April 5, 2016

**RE: Amended Subdivision Plan & Level III Site Plan Application  
Schlotterbeck Block – 117 Preble Street**

**1st floor plan  
lower level plan**

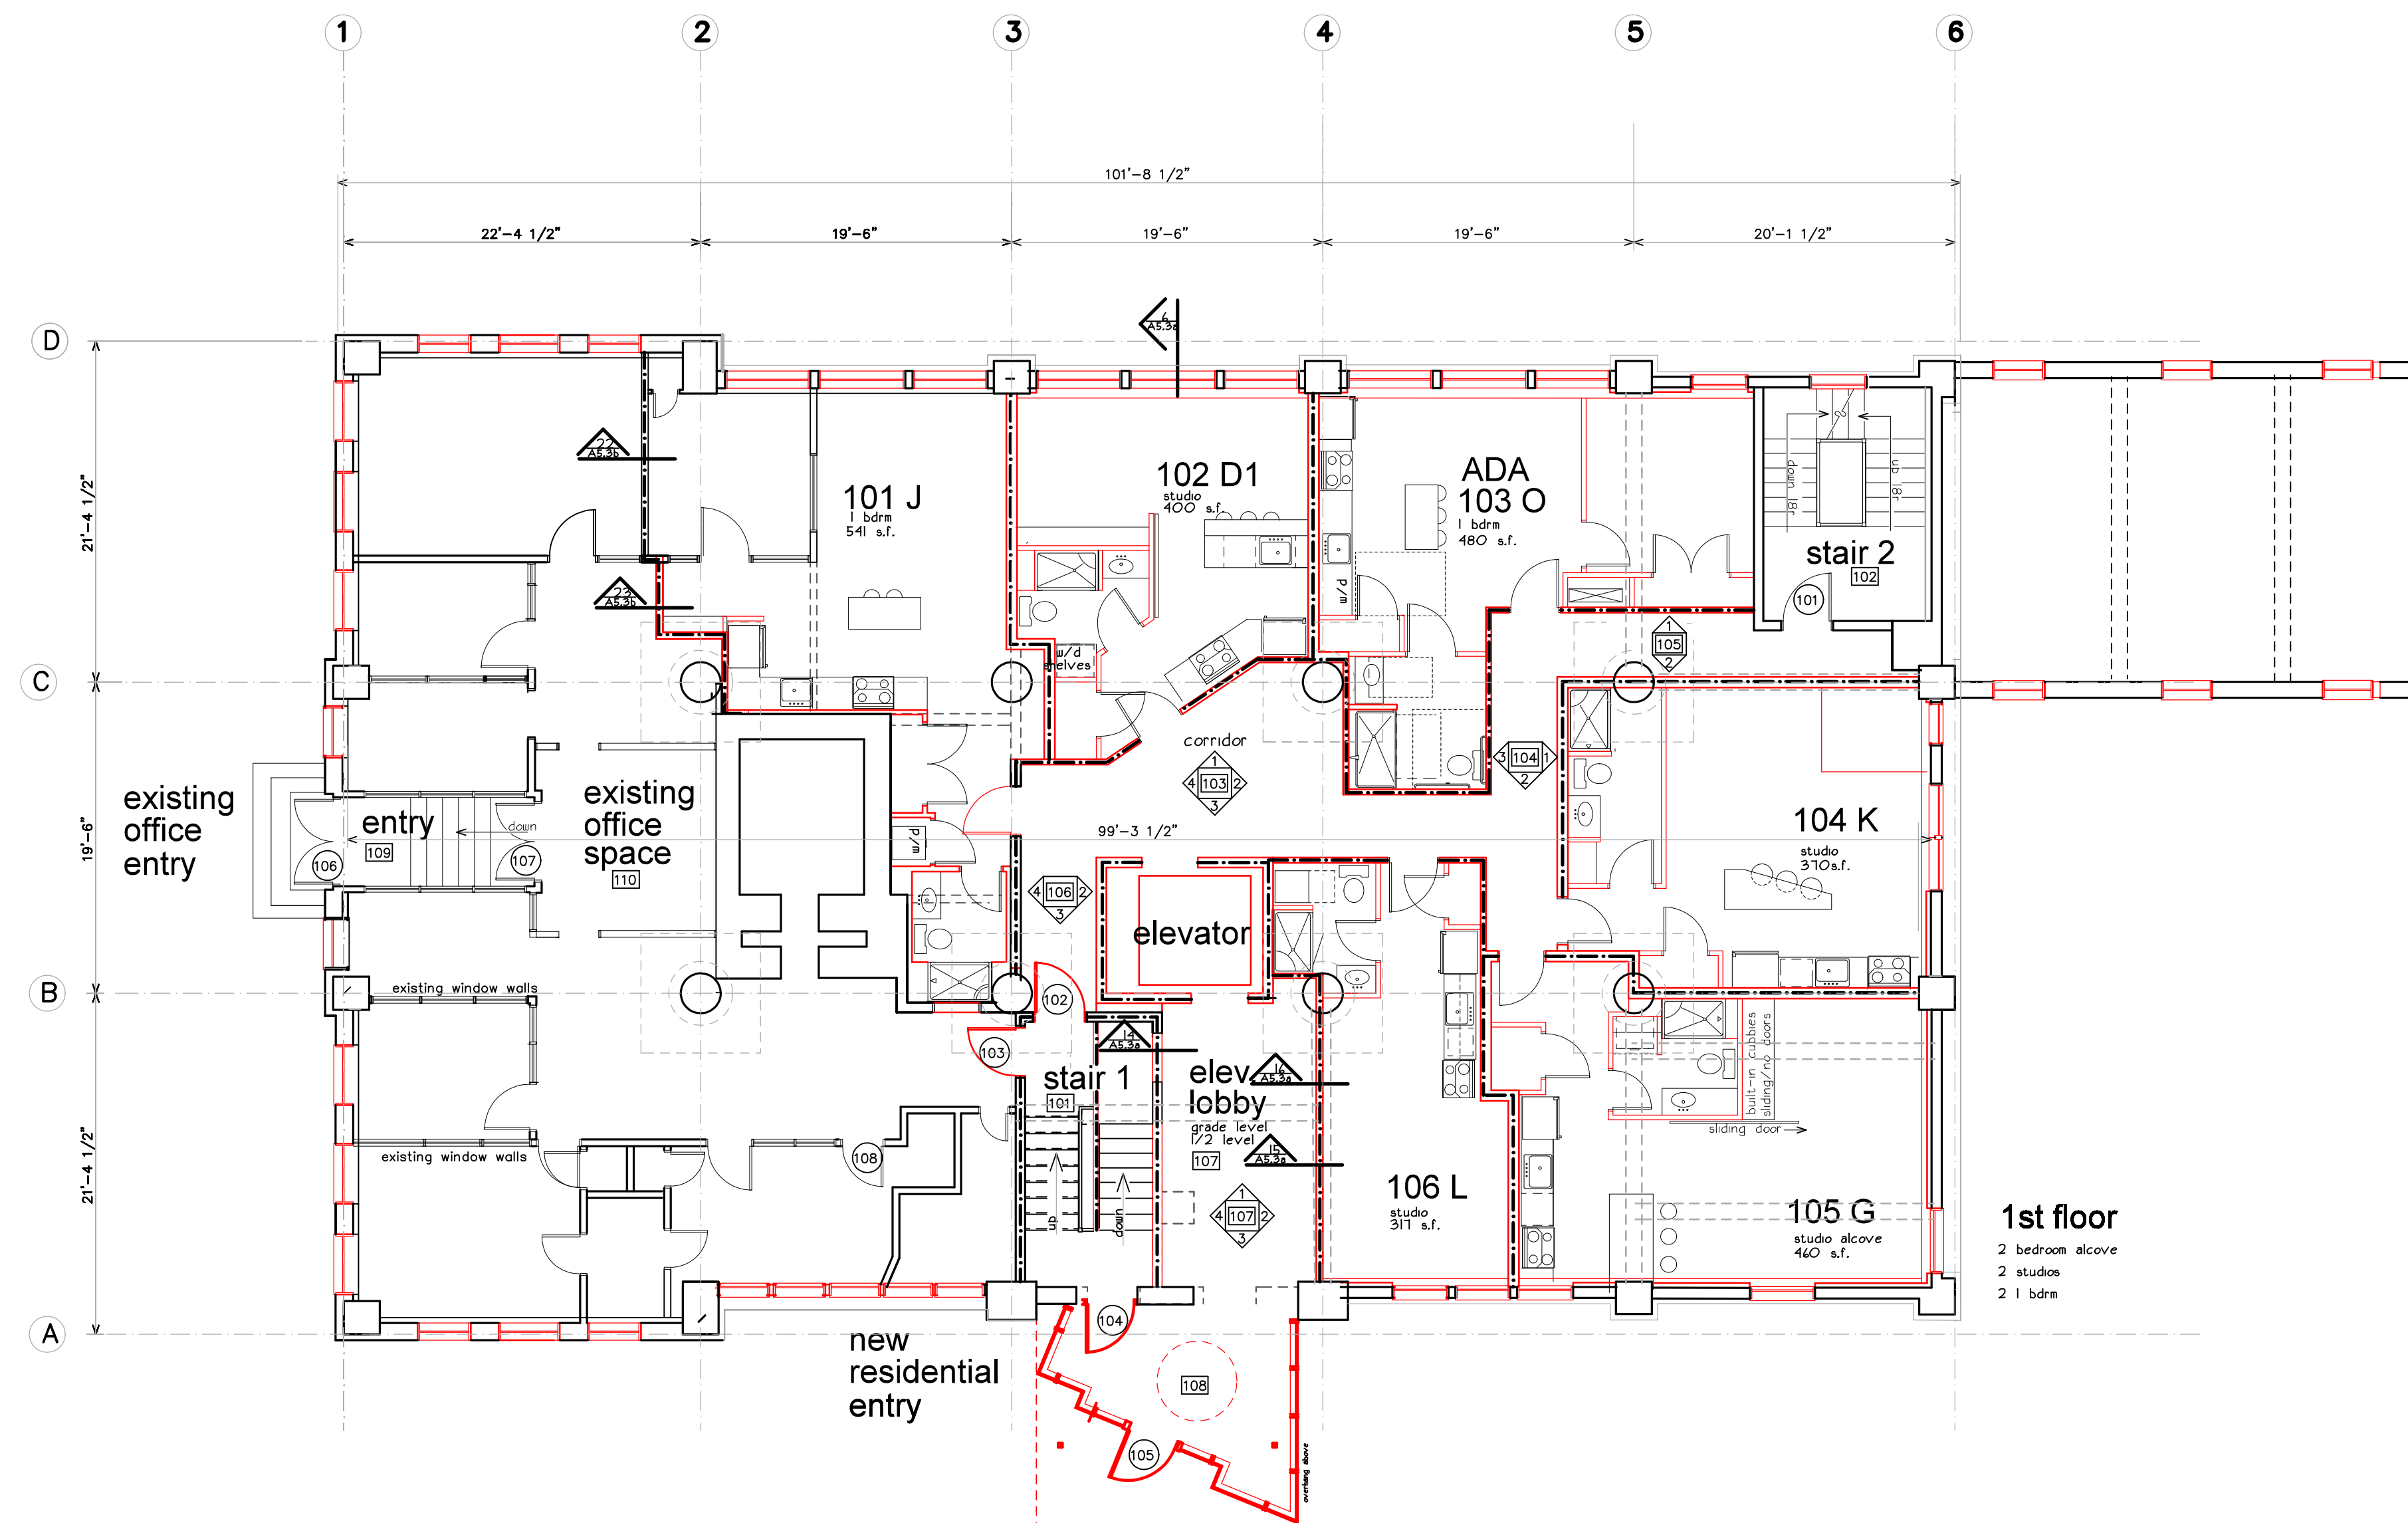
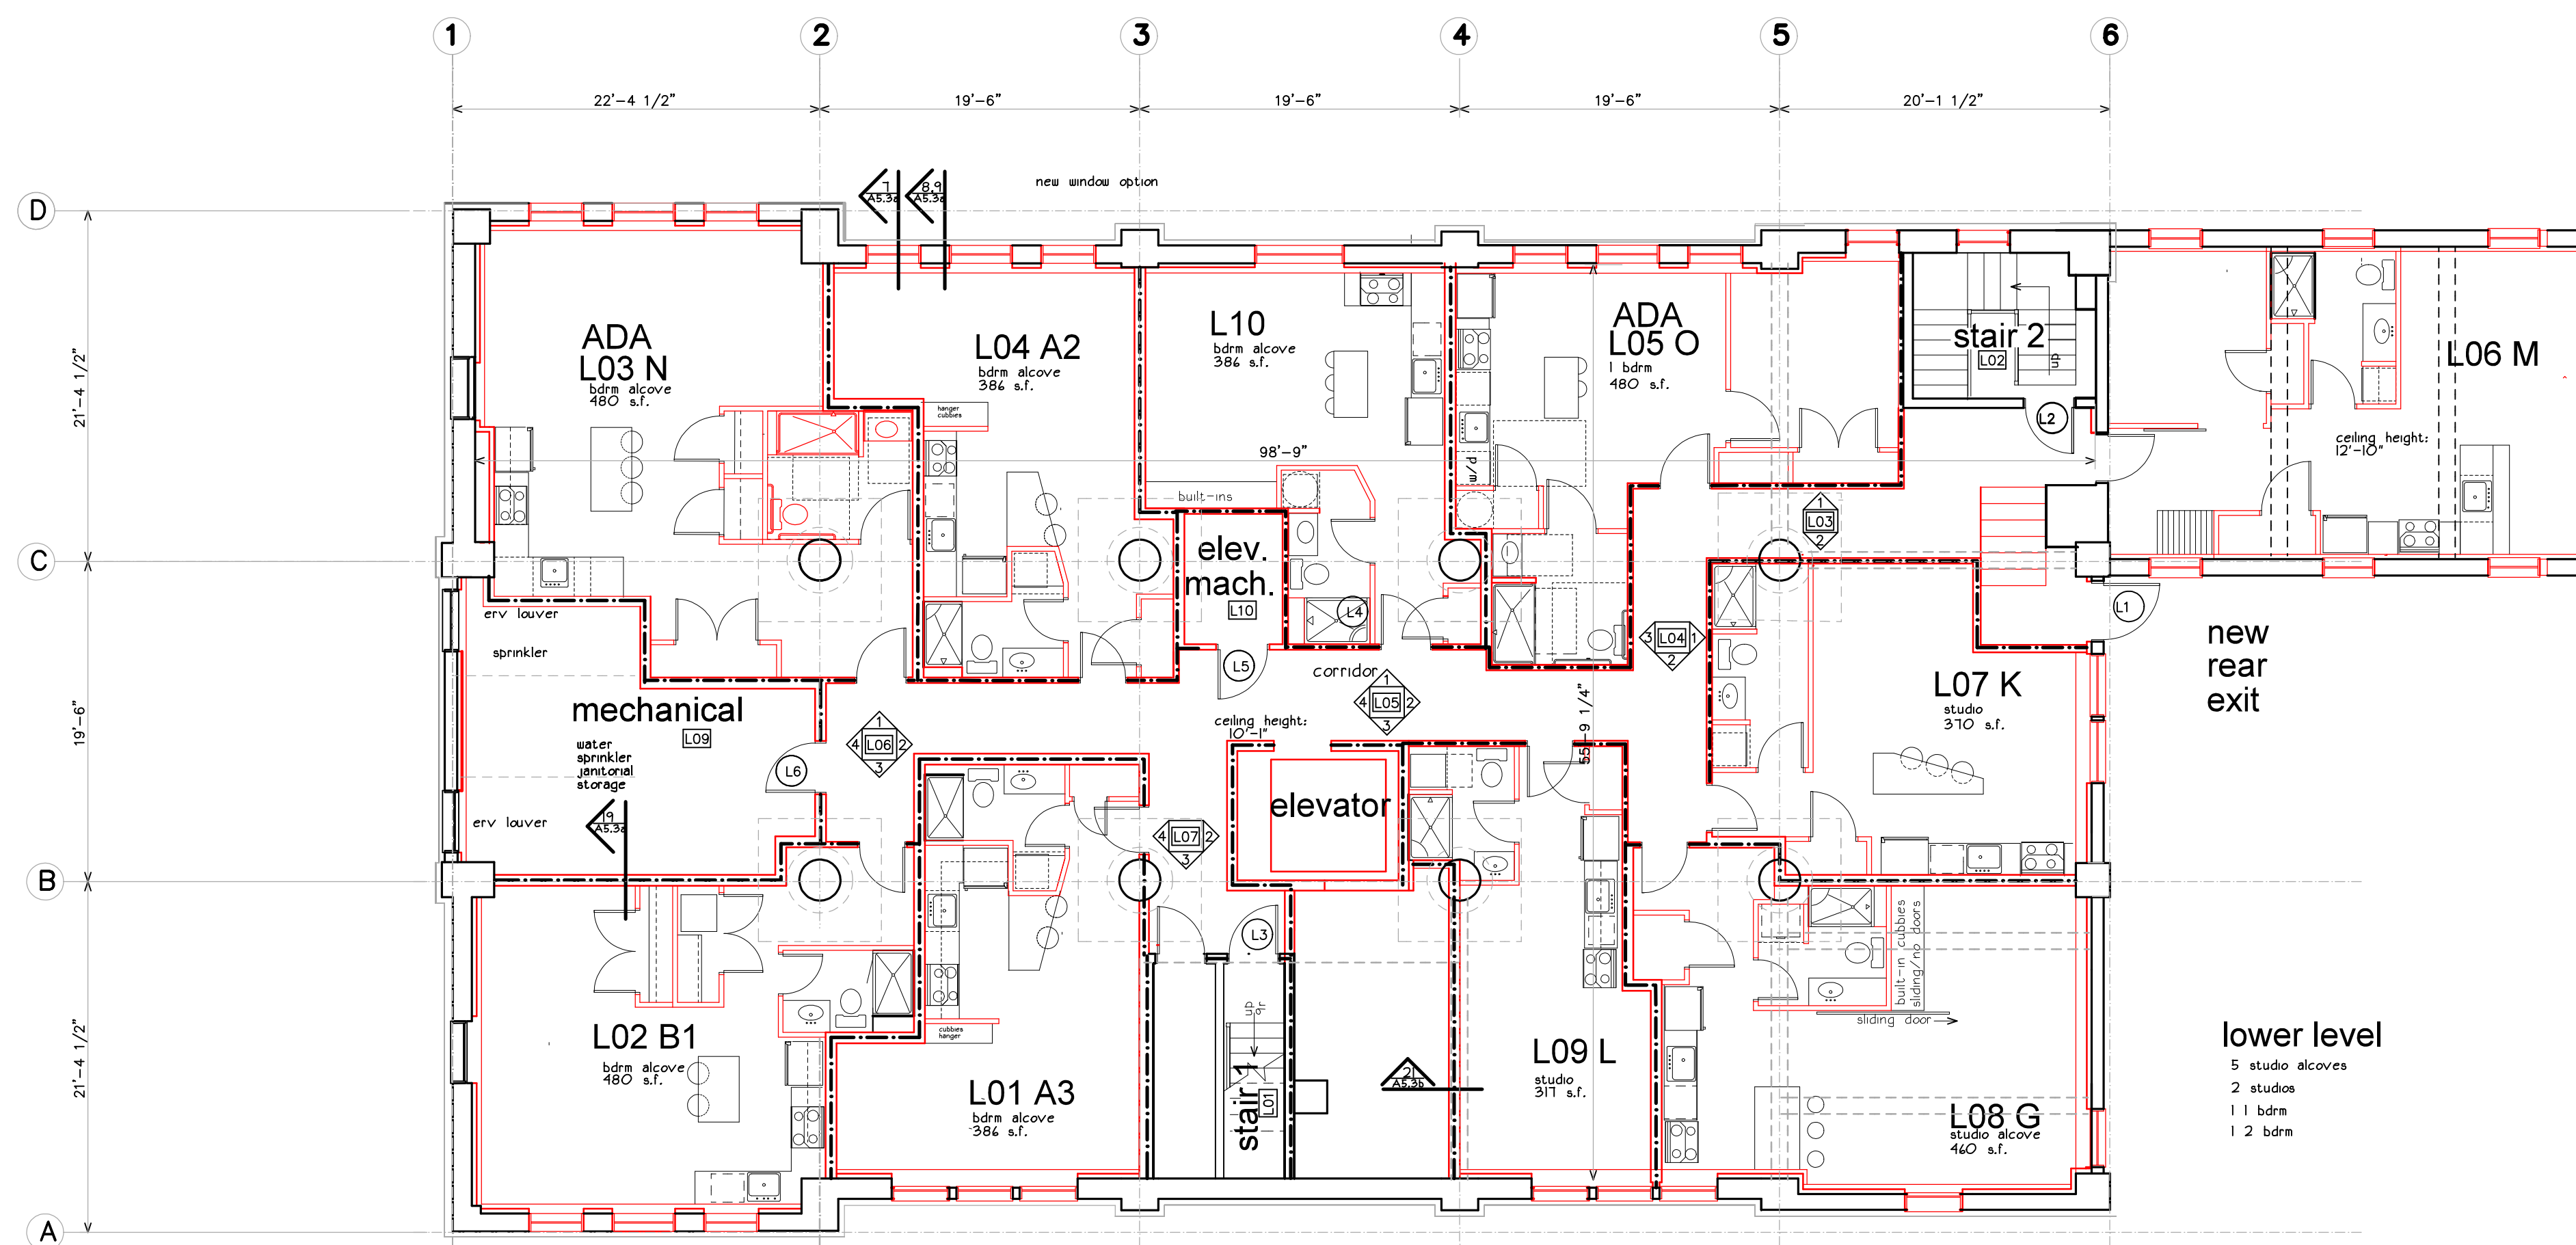
1. **Additional Unit:** At its December 15, 2015 meeting, the Planning Board approved Schlotterbeck Block LLC's Subdivision Application, which included the development of 55 units at the former Schlotterbeck & Foss building at 117 Preble Street. The applicant now proposes an additional unit in the building's basement, resulting in a total of 56 units and 1,750 s.f. of office space.

The attached Amended Subdivision Plan and Basement Floor Plan A1.1 have been revised accordingly.

Title: LAYOUT AND LIGHTING PLAN

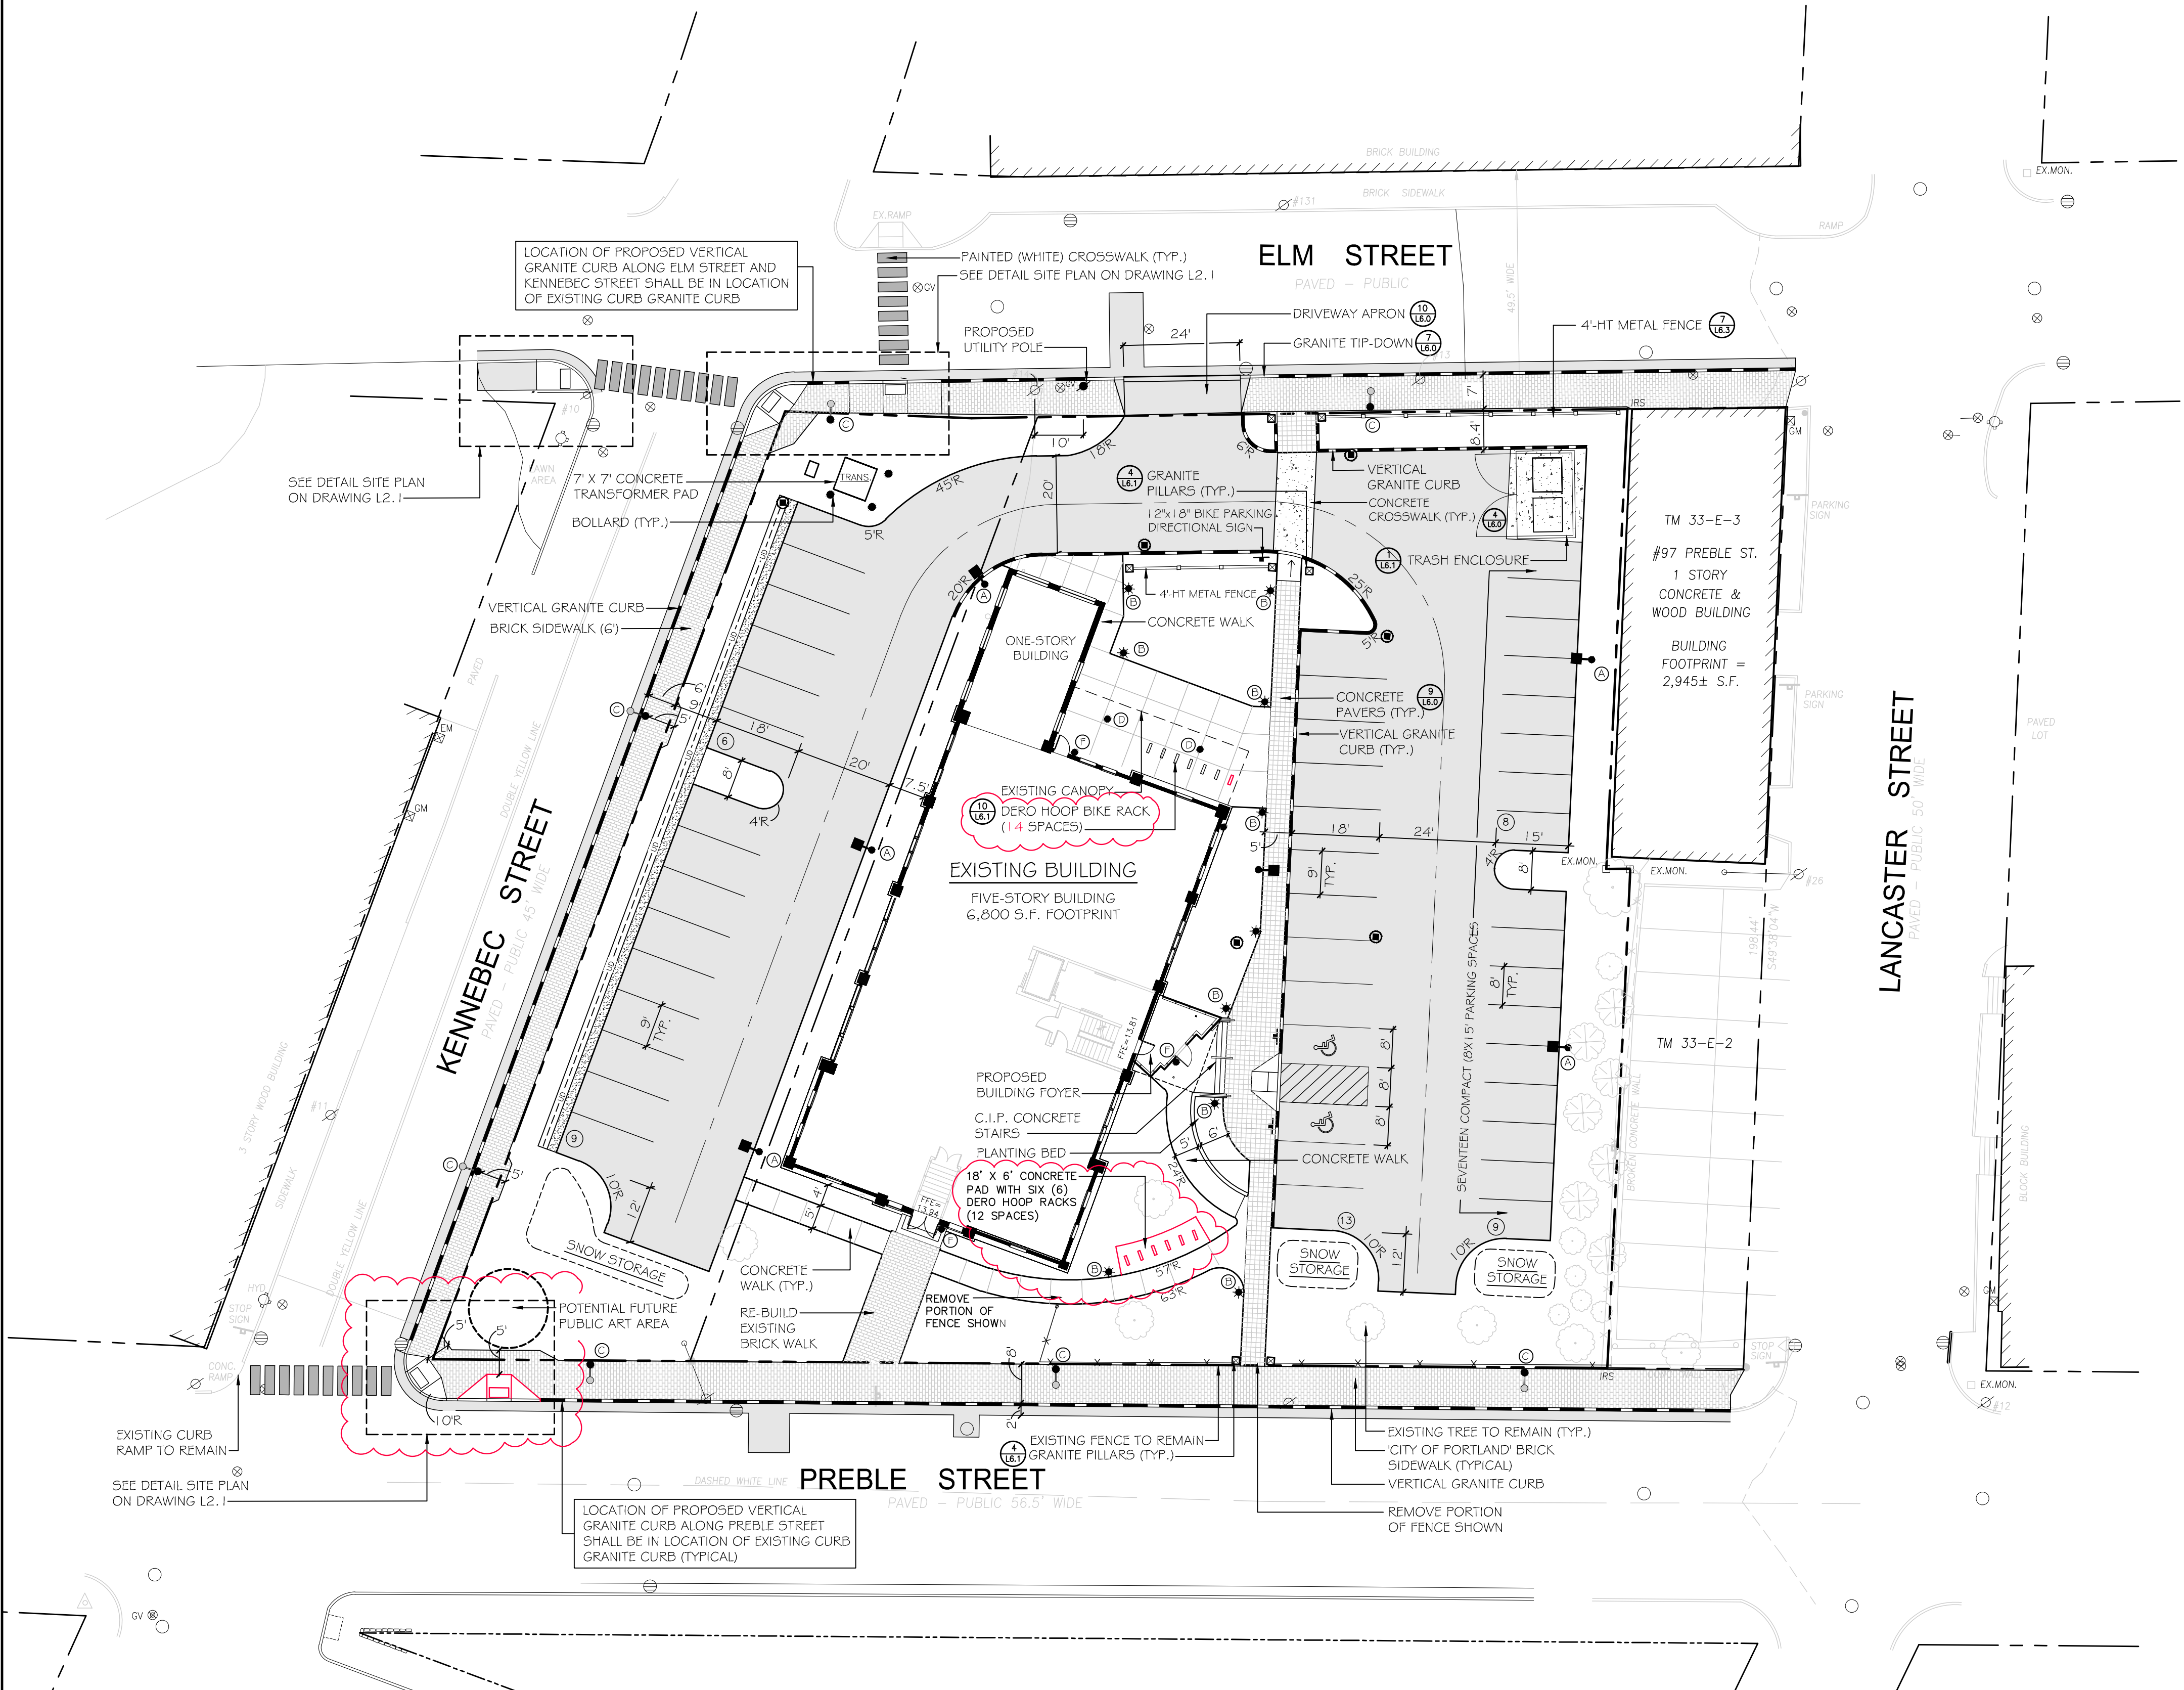
3. **Additional Bike Racks**: The additional unit eliminates the bike storage room in the basement. As a result, fourteen (14) exterior new bike parking space need to be located on the site. The attached revised L2.0 show an additional bike hitch under the canopy and six (6) additional bike racks on a concrete pad located near the building entrance. With these revisions, thirteen (13) bike loops are provided and 26 bike parking spaces will be provided.

4. **Additional Sidewalk Ramp and Pedestrian Easement**: The City's staff has requested an additional sidewalk ramp at the intersection of Preble and Kennebec Streets, as part of the December 2015 conditions of approval. The new ramp will require pedestrian easement on the applicant's lot. The attached Amended Subdivision Plan and sheet L2.0 show the new sidewalk ramp and the pedestrian easement. Also, attached Exhibit B also shows the detailed layout and grading the new sidewalk ramp.
